**Re: Summary of In-Ground Contamination – Ivanhoe Estate, Cnr Herring and Epping Roads, Macquarie Park NSW 2113.**

**IVANHOE ESTATE**

Corner of Herring and Epping Roads,  
Macquarie Park NSW 2113 (the site)

ATTACHMENT 1 – PROPOSED ADDITIONAL INVESTIGATION LOCATIONS

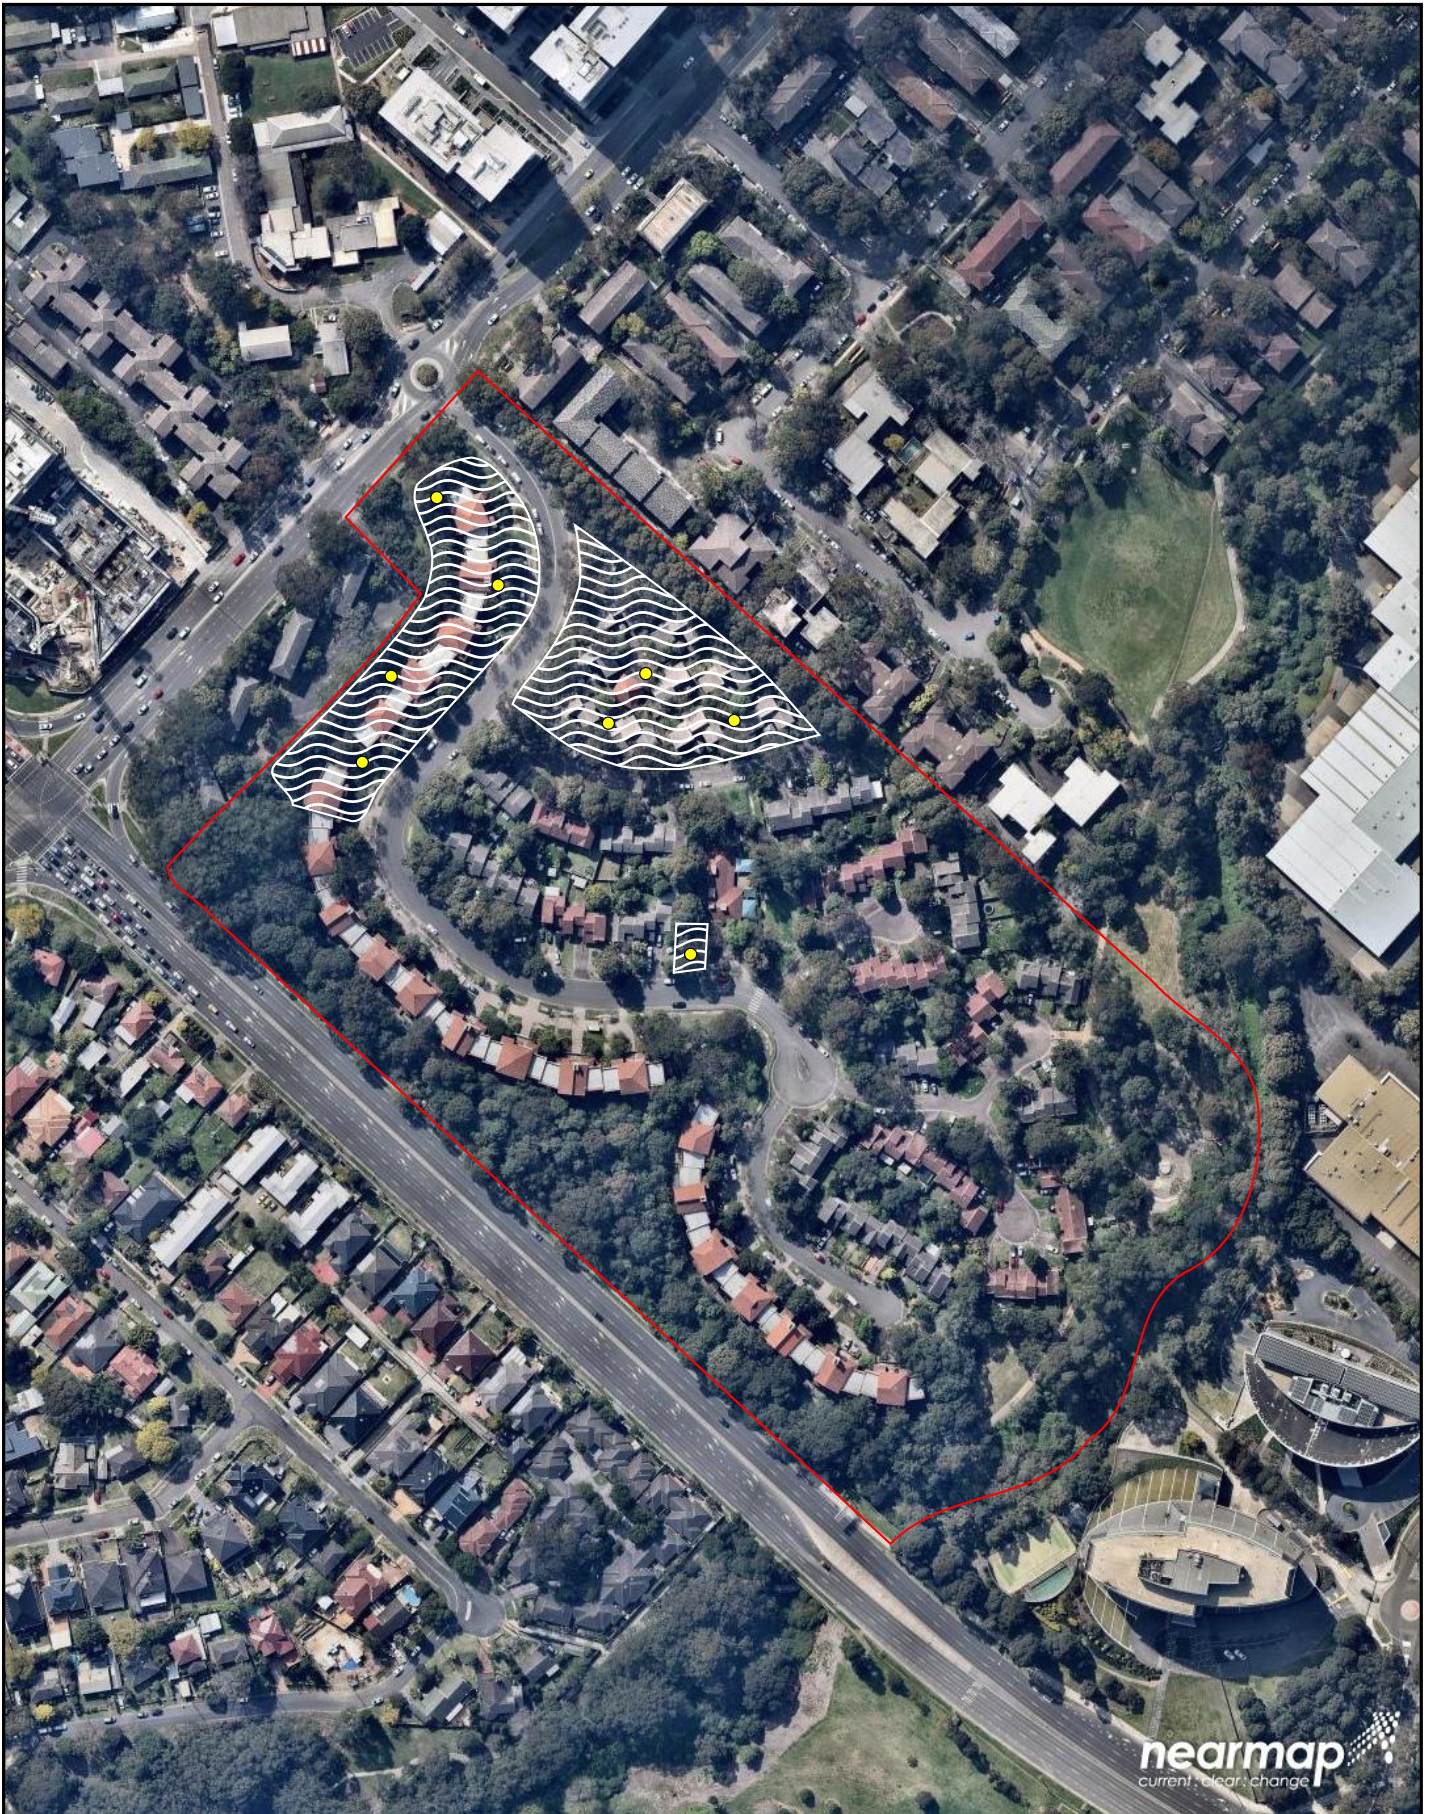
A data gap does however exist for the Altered Topography areas, which were only subject to perimeter sampling as part of the DSI. No information is available describing the origin of the filled soils and whether the soils were imported from off-site. The DSI recognised the likelihood for these areas to have been filled with imported materials including building and demolition waste and a potential therefore exists for asbestos to be present amongst mixed waste.

DLA recommend that additional visual inspections and limited sampling are performed across the central portions of the Altered Topography areas. The objective of the additional investigation will be to close out any issues relating to the potential presence of asbestos in filled and/or imported soils of the Altered Topography areas. Upon satisfaction of this data gap, DLA envisage that the risk of potential contamination in-ground will be low.

The proposed additional inspection and sampling locations are shown in **Attachment 1**.
